Engineers Comments Regarding Surface Water Drainage

Application No: BR/128/20/DOC
Registered: 15th June 2020
Site Address: 9 Westloats Lane Bognor Regis PO21 5JZ
Description of Works: Approval of details reserved by condition imposed under BR/219/18/PL for condition 4-surface water drainage; 5-colour schedule of materials & finishes, 6-dustbin enclosures details; 7-electrical vehicle charging points, 8-incorporation of decentralised, renewable, low carbon energy supply system, 9-vehicular access details & 11-cycle parking space details.

Project
 Proposed Site Plan
 Date
 2nd May 2018
 Scale
 1 : 500

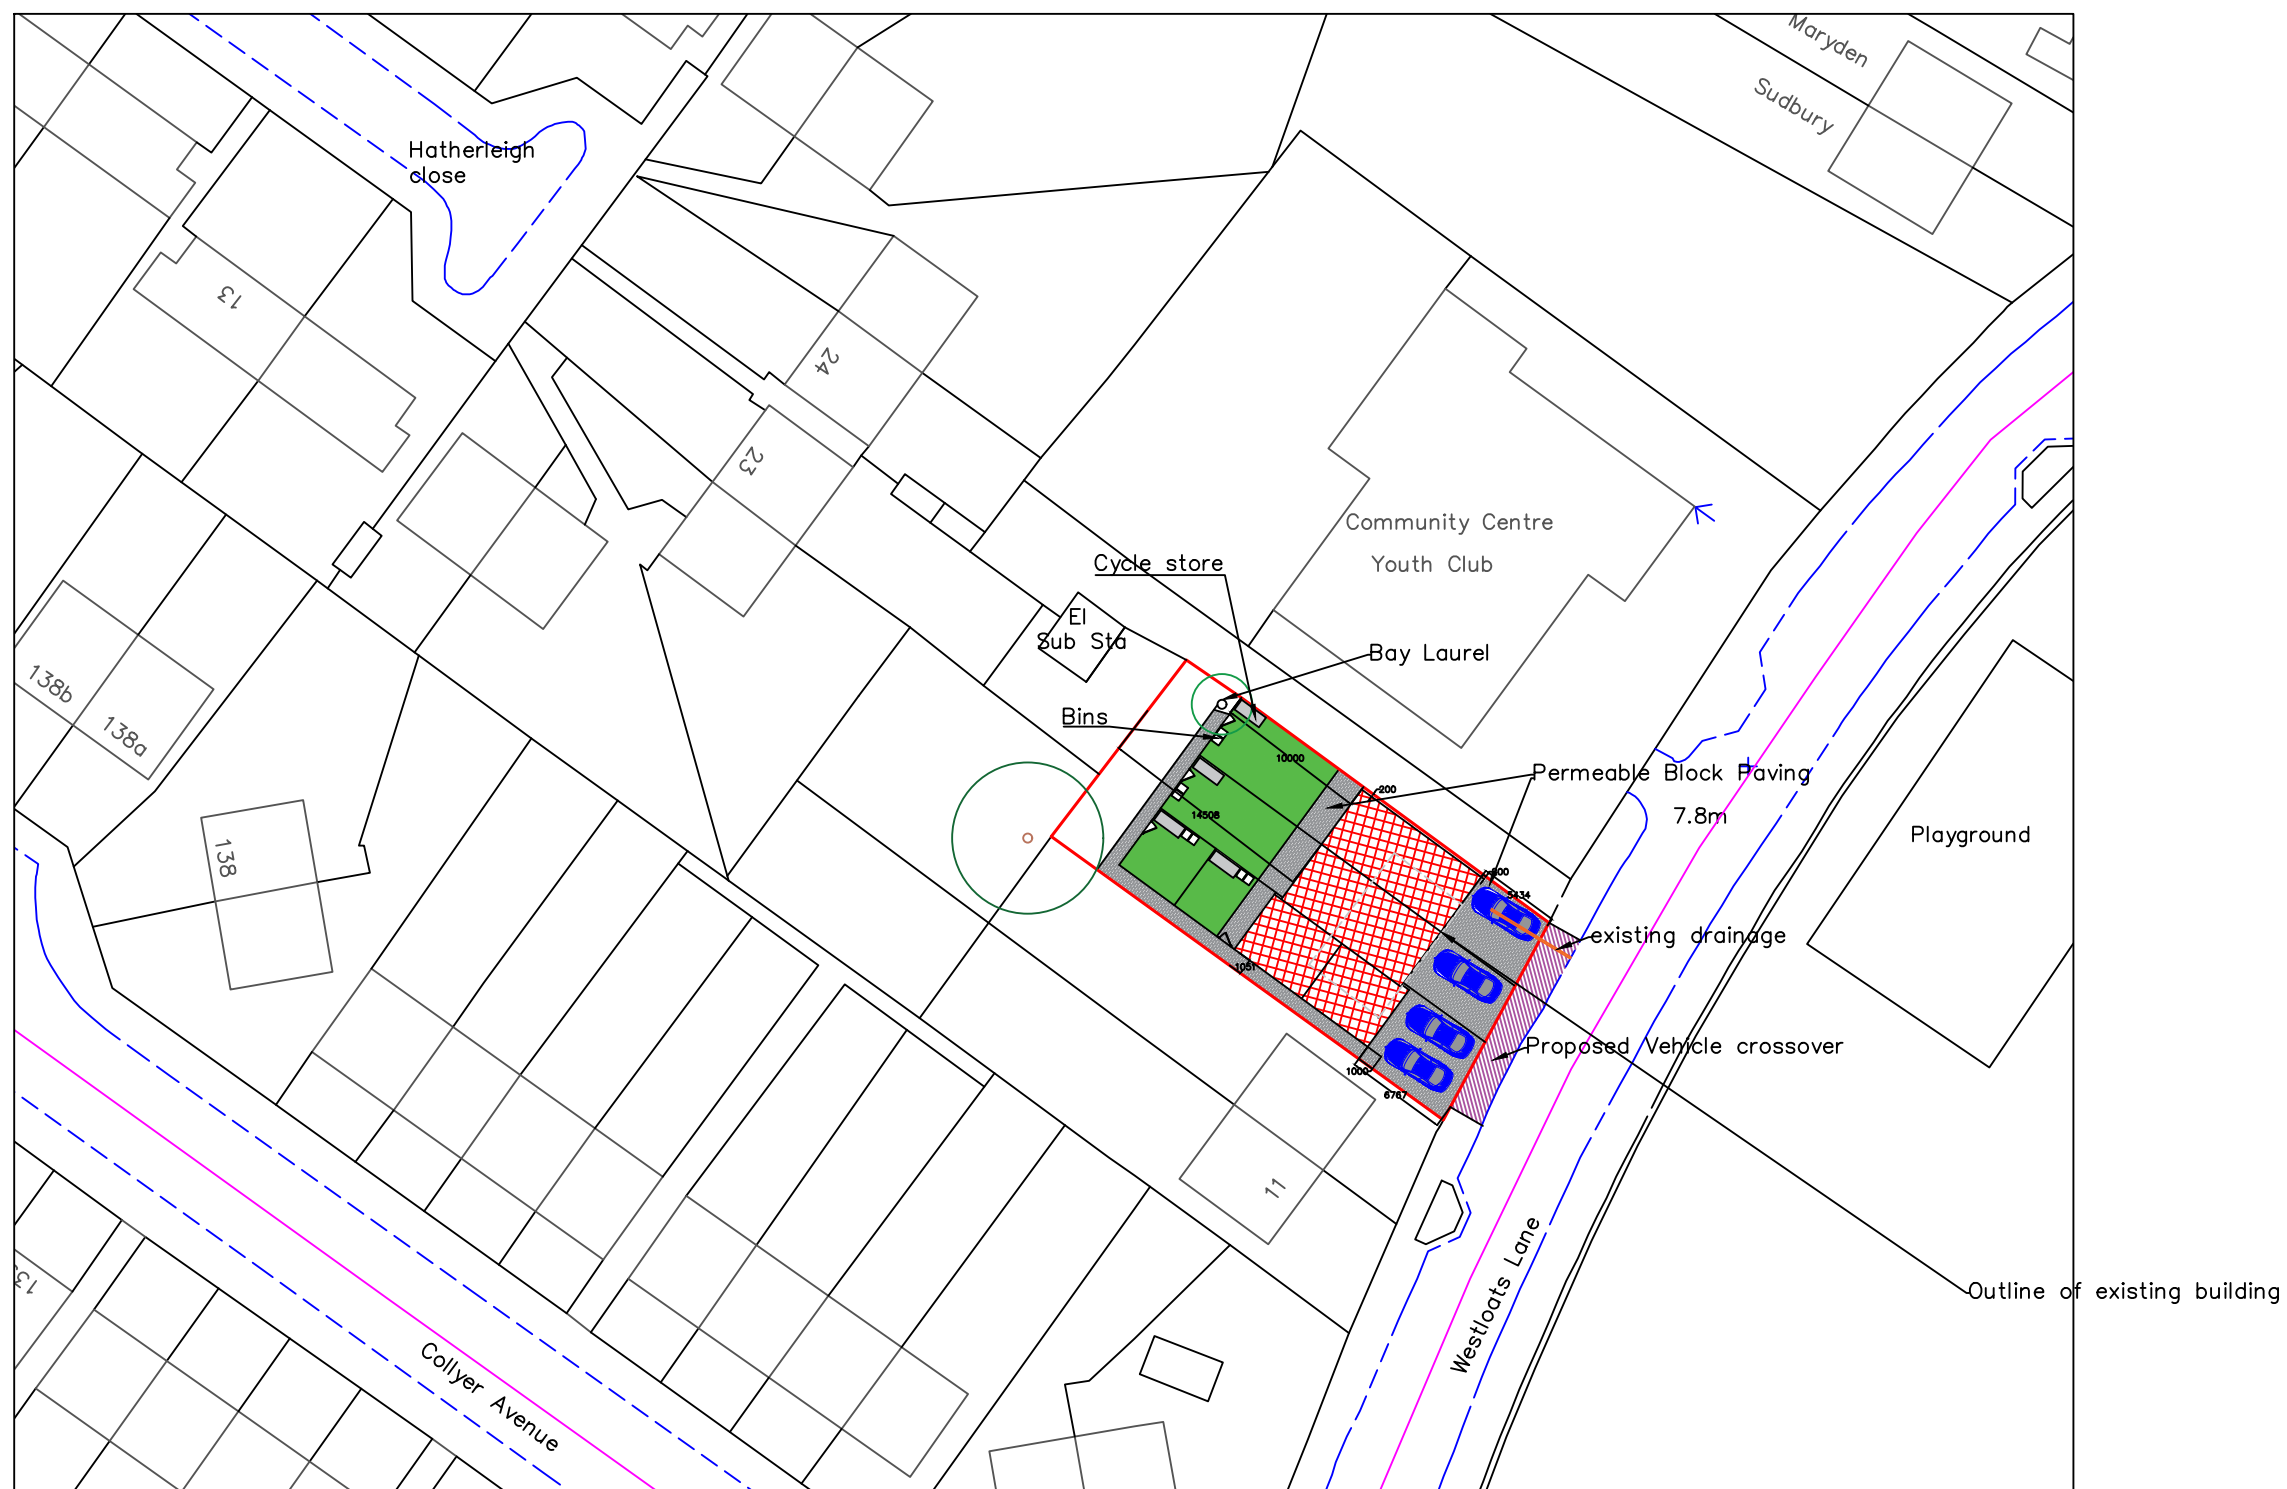
5. No construction detail drawings have been supplied (Soakaway, silt trap, pipe bed and surround minimum).
6. Permeable paving is noted on the site plan, but there are no calculations for this. Nor is it included in the drainage layout. Nor do we have a construction detail for it.

Project Proposed soakaway Plan	Sheet 4
Date 13th May 2020	
Scale 1 : 500

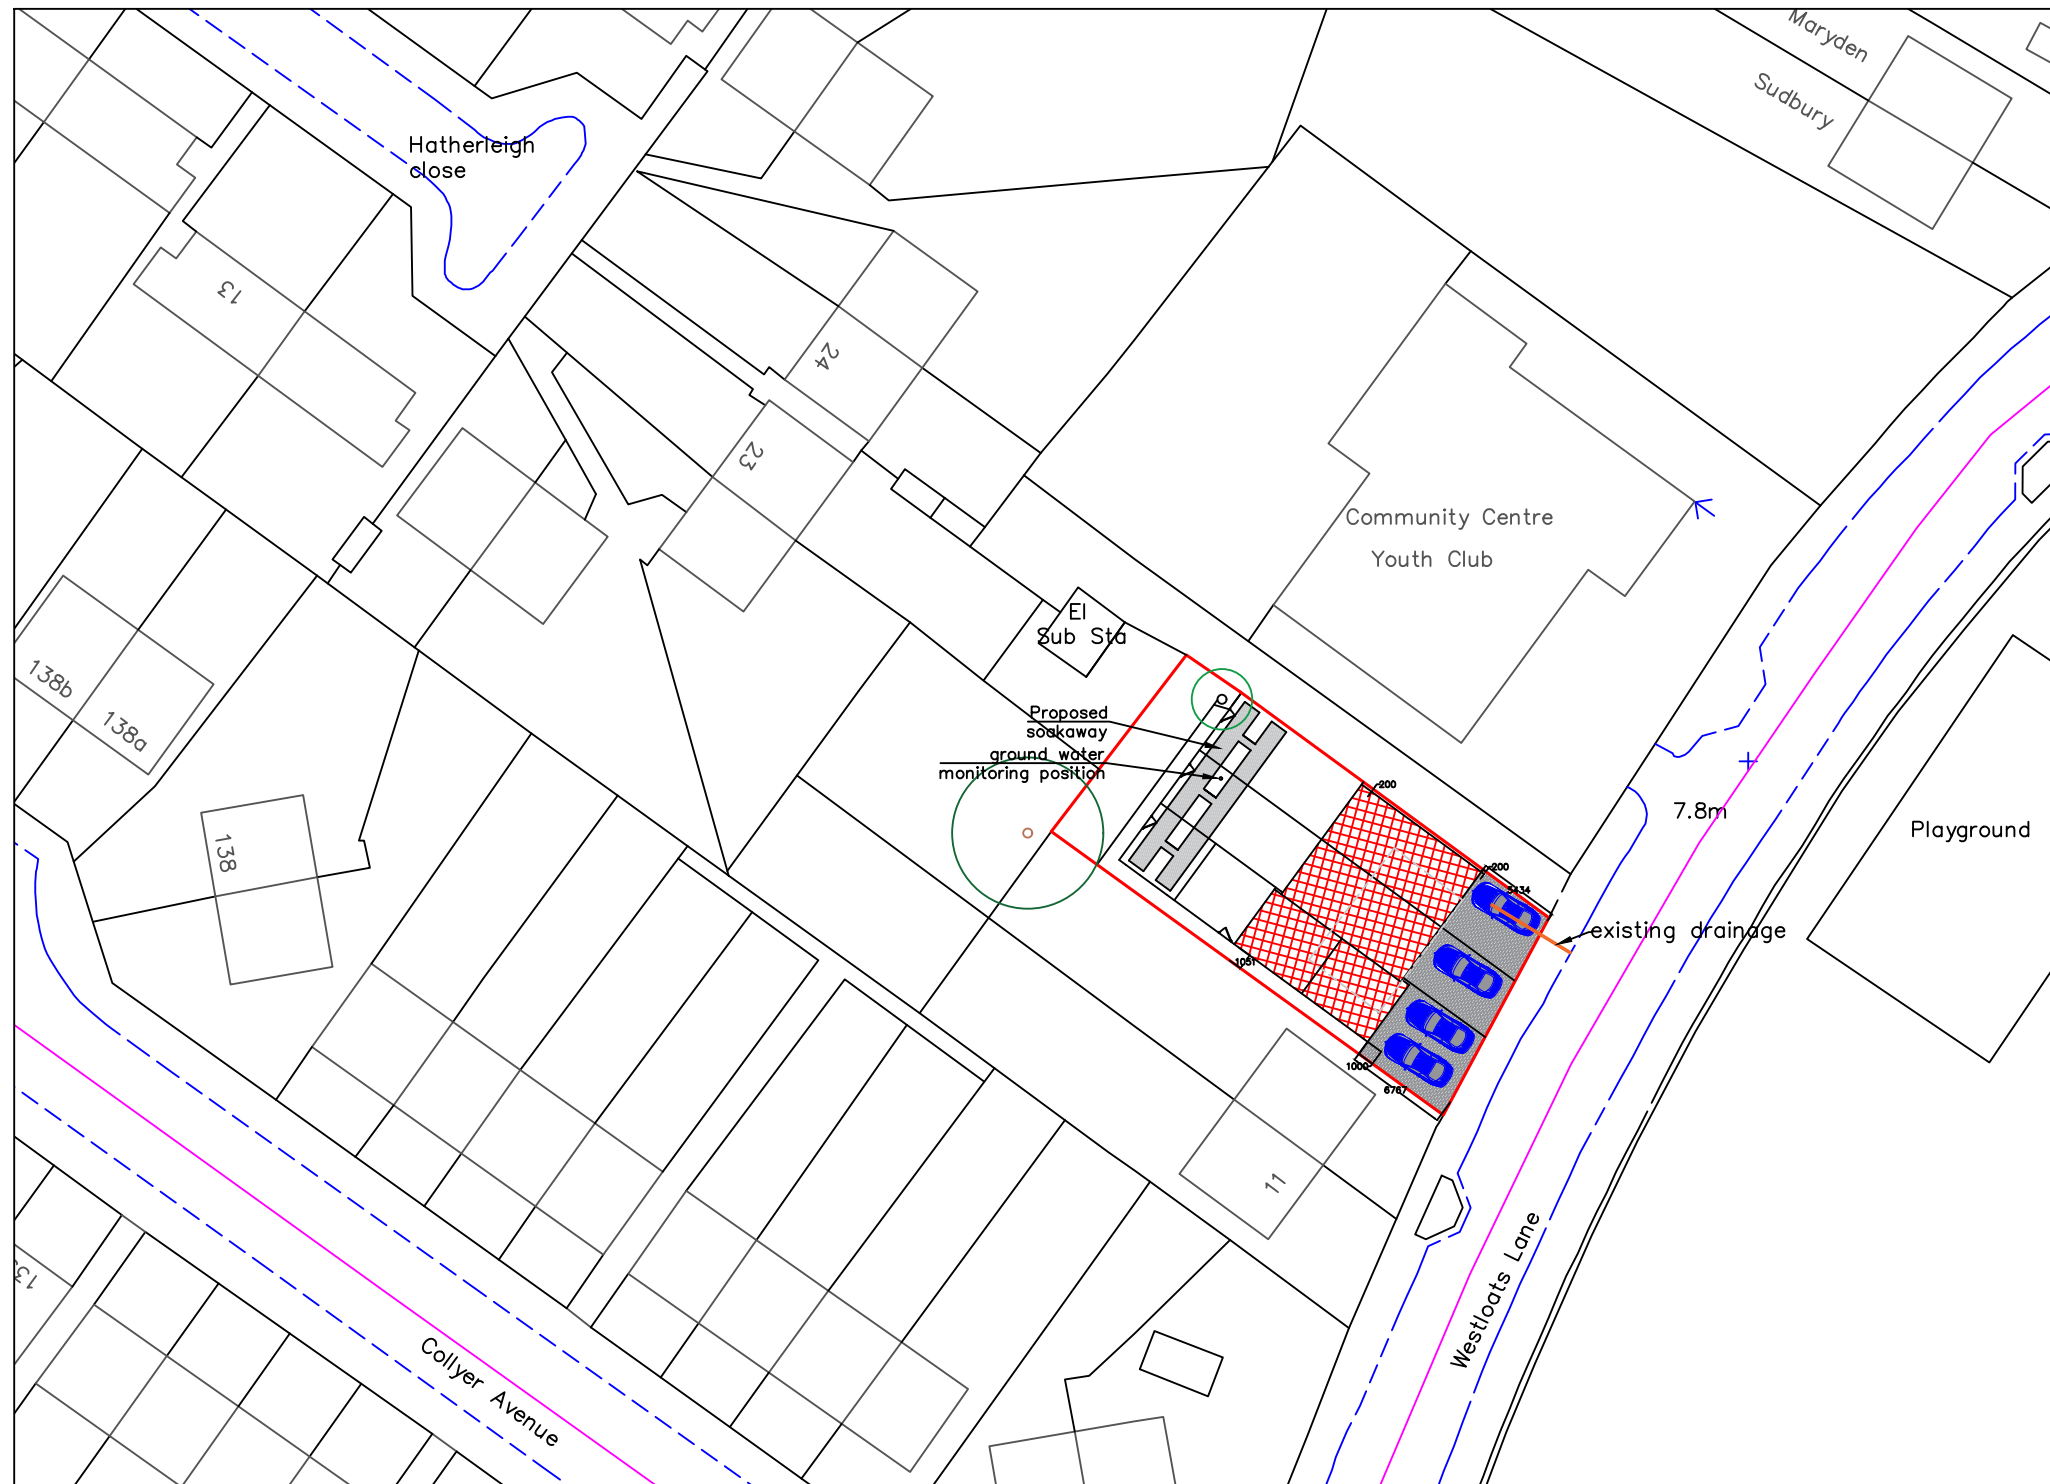
1. It appears that only one infiltration test was completed. BRE 365 stipulates that the trial pit should be filled three times in succession and the worst rate used for the calculations. Please evidence any other infiltration tests completed.
2. The Soakaway Plan does not include the necessary level of detail as described in the Drainage Checklist. (Pipes, silt traps/manholes/inspection chambers, invert levels, cover levels, gradients/falls).
3. No construction detail drawings have been supplied (Soakaway, silt trap, pipe bed and surround minimum).
4. Permeable paving is noted on the site plan, but there are no calculations for this. Nor is it included in the drainage layout. Nor do we have a construction detail for it.
5. Any soakaways need to be kept a minimum of 1.5m from the property boundaries.

3. Using an infiltration rate of 1.45×10^{-6} the half drain time for a ten year event (+40% climate change) exceeds 24 hours.
4. The Soakaway Plan does not include the necessary level of detail as described in the Drainage Checklist. (Pipes, silt traps/manholes/inspection chambers, invert levels, cover levels, gradients/falls).

7. Any soakaways need to be kept a minimum of 1.5m from the property boundaries.
